CITY OF PORTLAND, MAINE

August 14, 2015

Project Name: **Subdivision of the McAuley site & conversion of the Motherhouse for senior housing**
Project ID: #2015-110
Address: 605 Stevens Avenue CBL: 136 E006001
Applicant: Motherhouse Associates, LP & Sea Coast at Baxter Woods Associates, LLC
Planner: Jean Fraser

TO: Jean Fraser, Planner
FROM: David Senus, P.E.
DATE: August 5, 2015
RE: Motherhouse Senior Housing, Final Level III Site Plan Application

Drawing file: 1. Original Plans / L1.0-TREE-PRESERVATION-PLAN.pdf

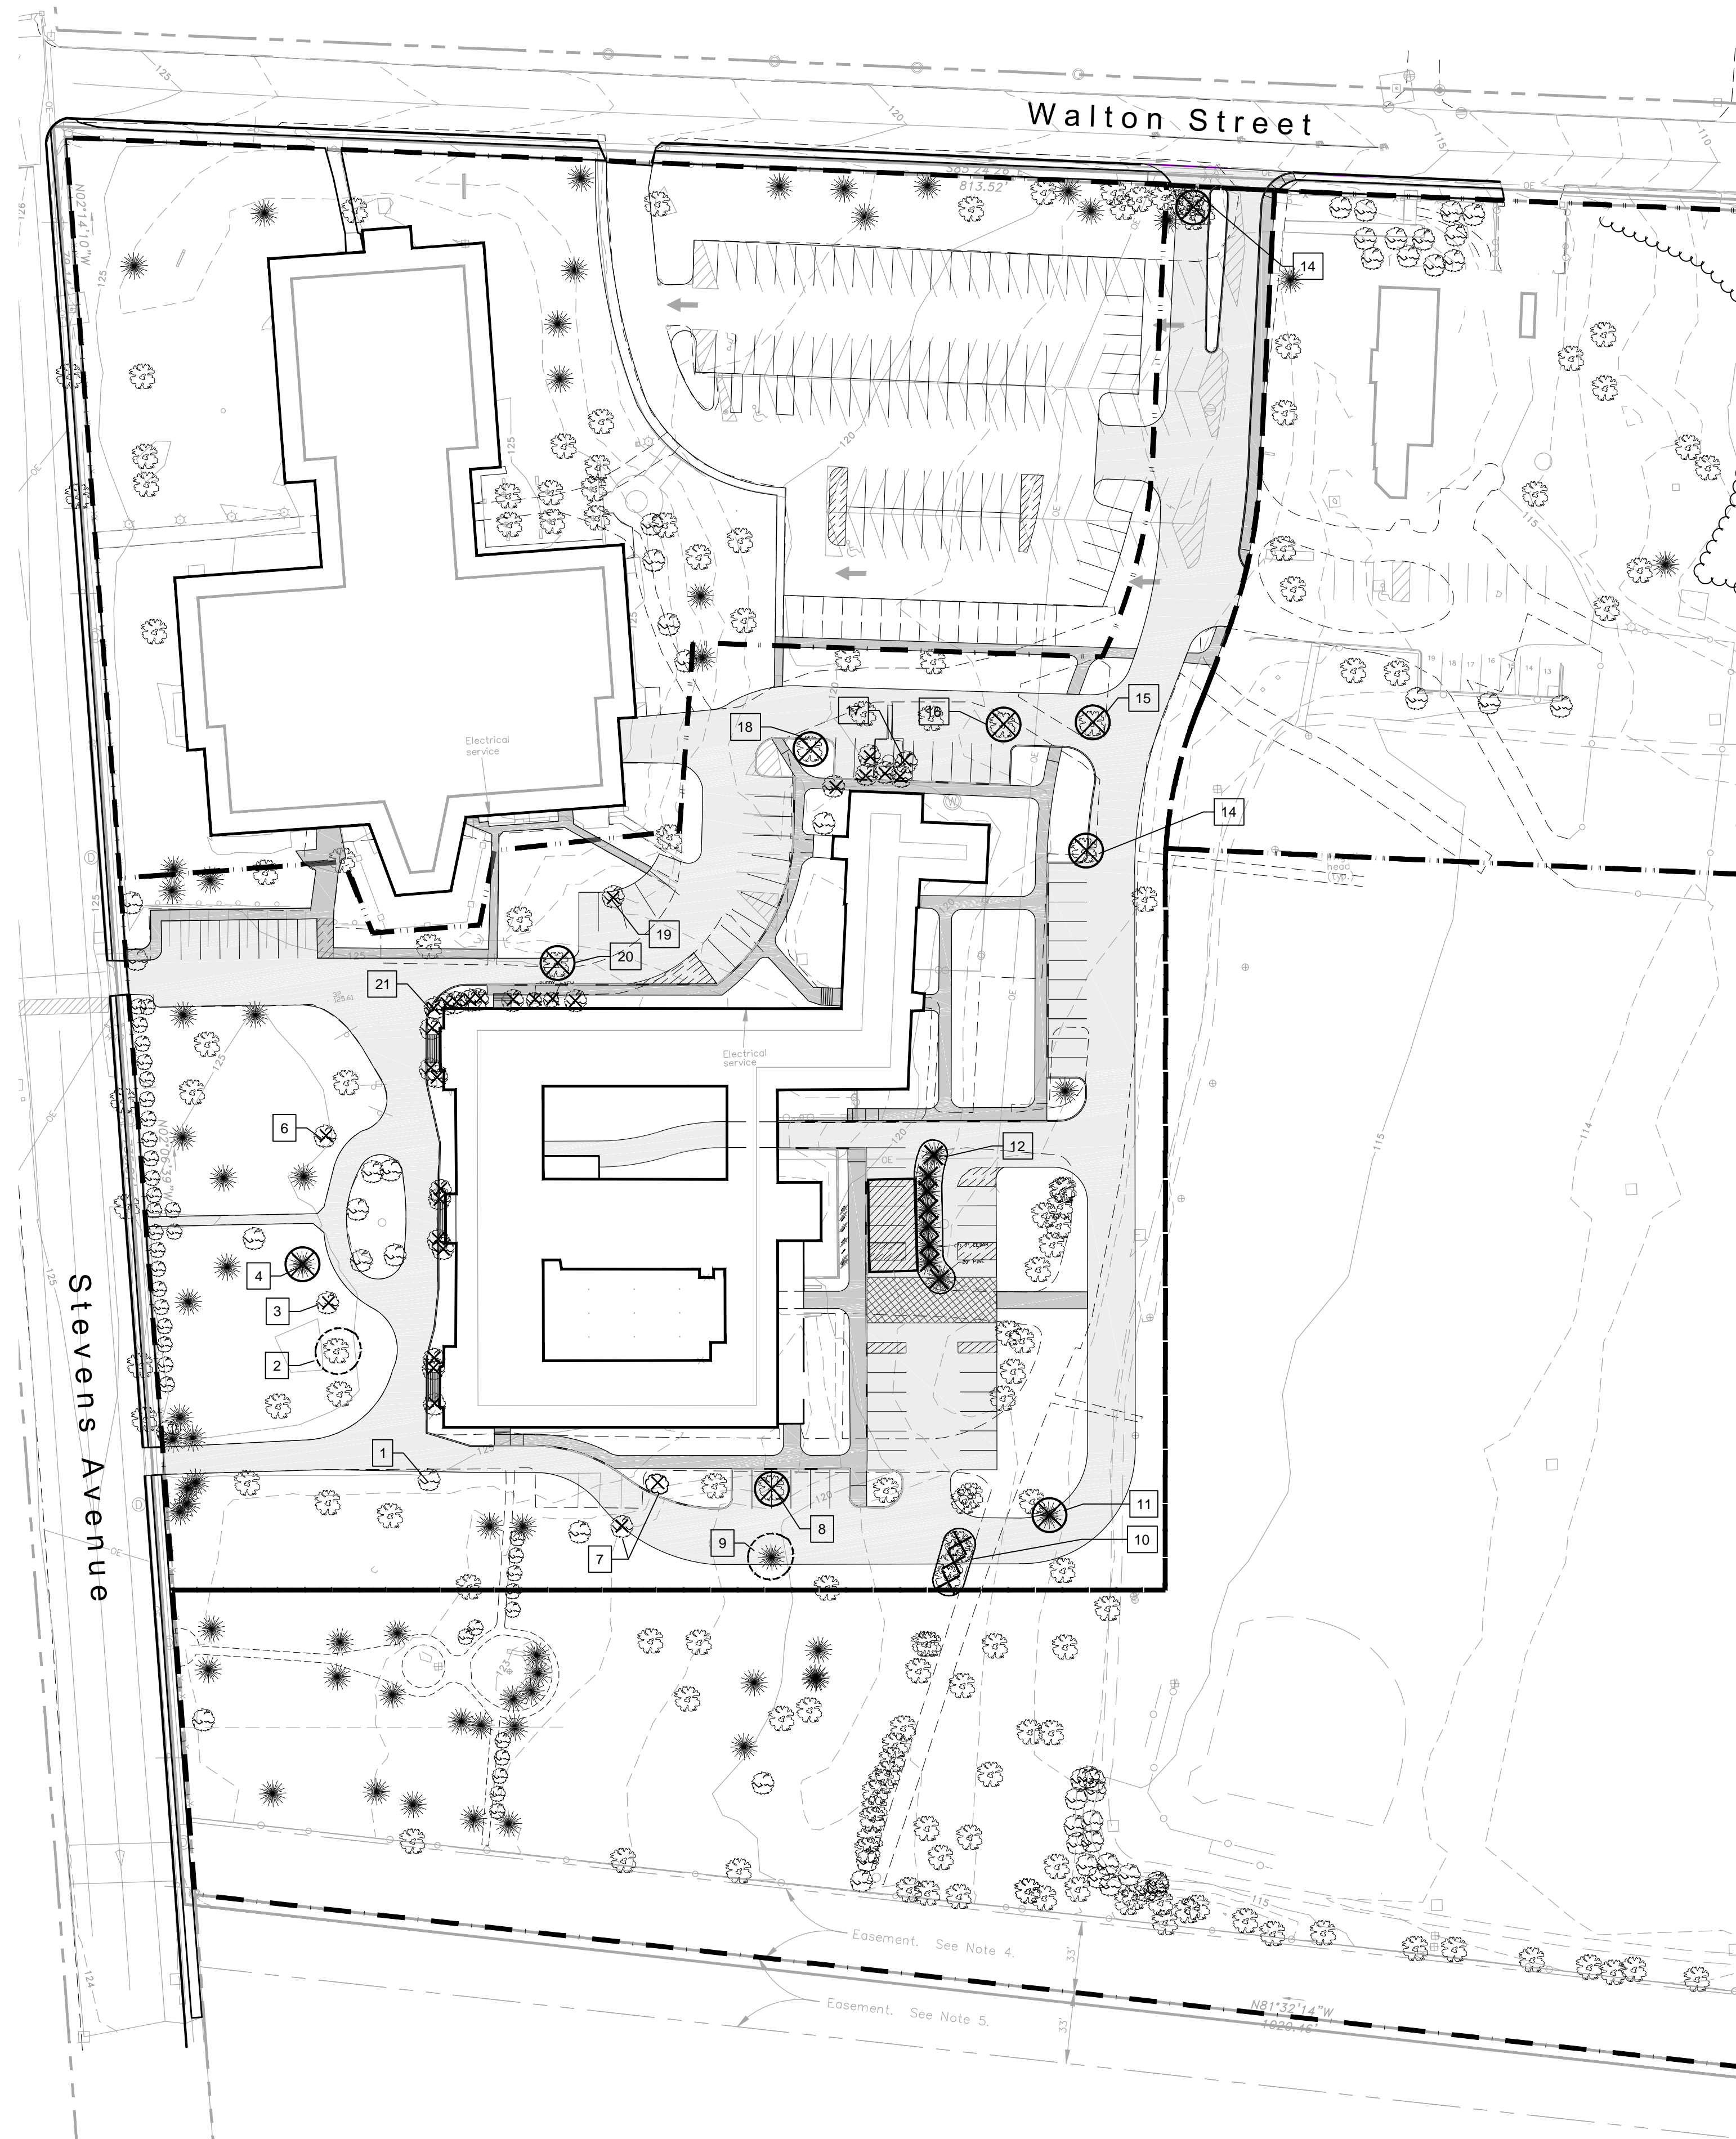
The 'tree save' plan seems reasonable and attempts to save the heritage old growth Red Oaks lining the former roadway. New trees and landscape: overall meets approval with the exception of the small crescent shaped parking lot near the McAuley School building, see graphic below. This area does not appear to have any landscape treatment. The project also calls out for a 'relocated spruce', it is our experience that transplanted trees generally do very poorly in the long run, great if they want to try, the performance guarantee should cover an additional \$500. for replacement.

Recommendations - 'Tree Save' areas within construction zones shall be protected with fencing and tree protection measures on root zone. No storage of equipment or materials within in the 'drip line' of trees, other than on paved surfaces. The large heritage Red Oaks are a primary landscape / historic feature and should be a priority area for followup tree care. This includes deadwood pruning and soil aeration along with strict enforcement of 'tree save' measures, including fencing, following ISA trees & construction recommendations see web links. Rain garden construction may impact root zones and careful coordination is needed between project team and the City Arborist.

- iii. That the recommendations of the City Arborist in comments dated 7.22.2015 regarding the protection of preserved trees and follow up tree care (particularly large heritage Red Oaks) shall be advised to all contractors and implemented during construction and after, to include no storage of materials within the drip line of trees and tree save measures as per ISA trees and construction recommendations as noted.
